Address: 1 Stainecross Avenue Huddersfield HD4 5HZ

| Application number: 2024/92983 | |
| What is the application for?: | Erection of detached garage (part retrospective) |

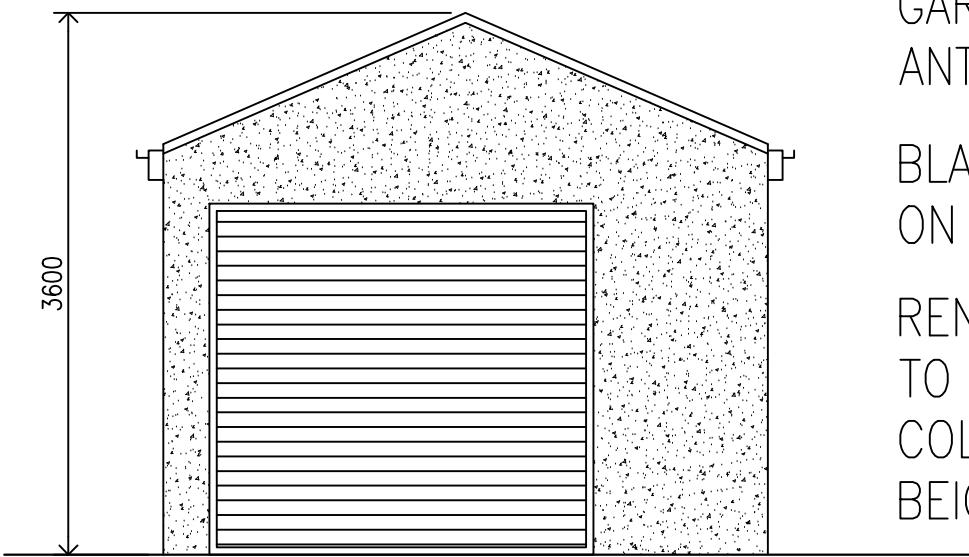
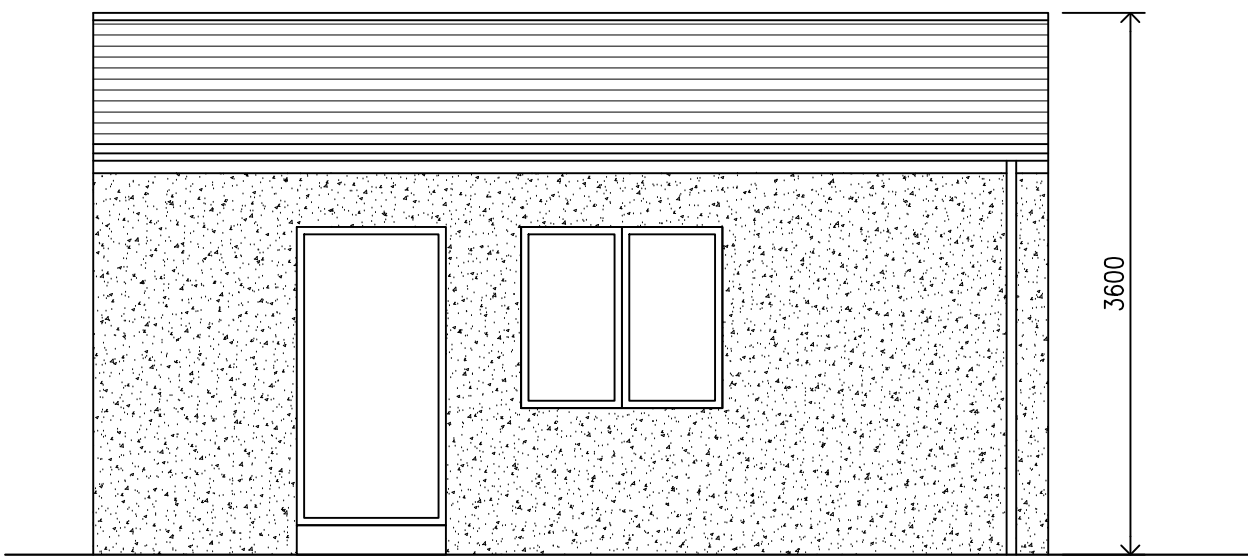
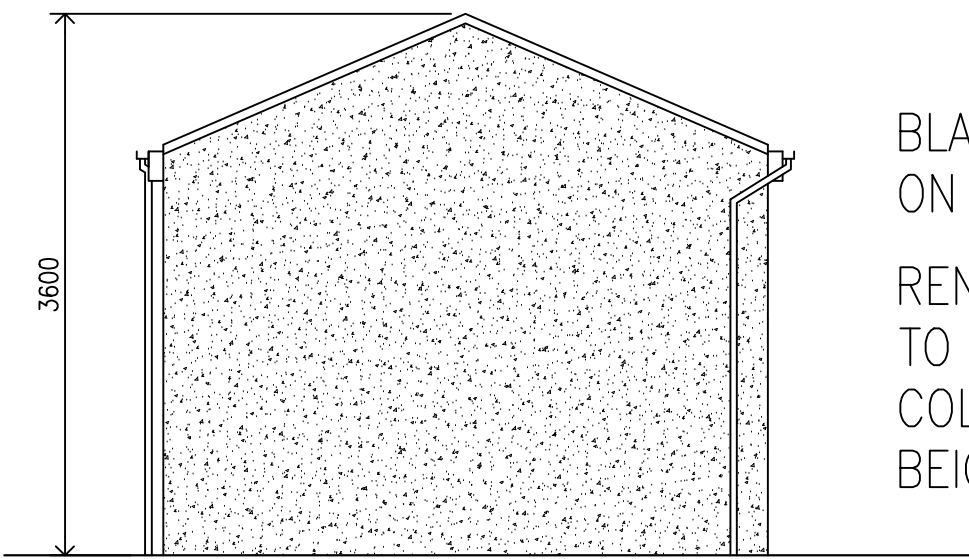
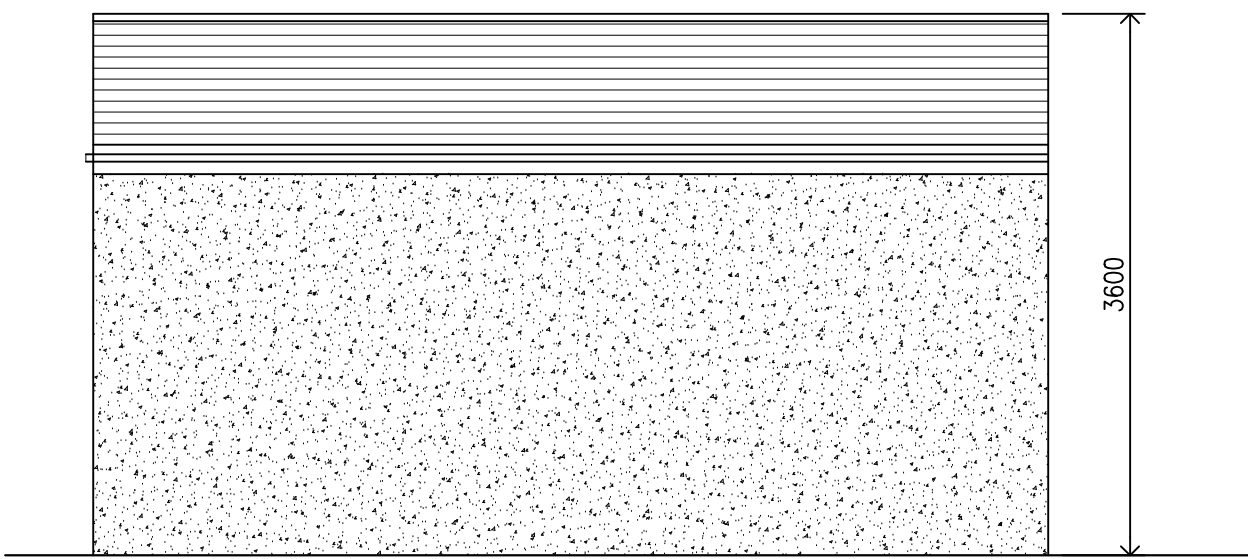
| <p>Currently there is an unsafe building with unsafe roof, that crosses the boundary line and allows rain water to flow into the neighbouring garden. Therefore there is construction proof there, that does not respect U.K. building regulations and laws.</p> <p>The original garage had a safer flat roof that kept rain water on the 3 Stainecross Avenue side. The new plan is very similar to the previous plan and the dual pitched roof would still cross the boundary line with its rainwater. In the current situation legally only a flat roof would comply with U.K. laws and regulations and would not trespass land boundaries, with it's rainwater.</p> | |
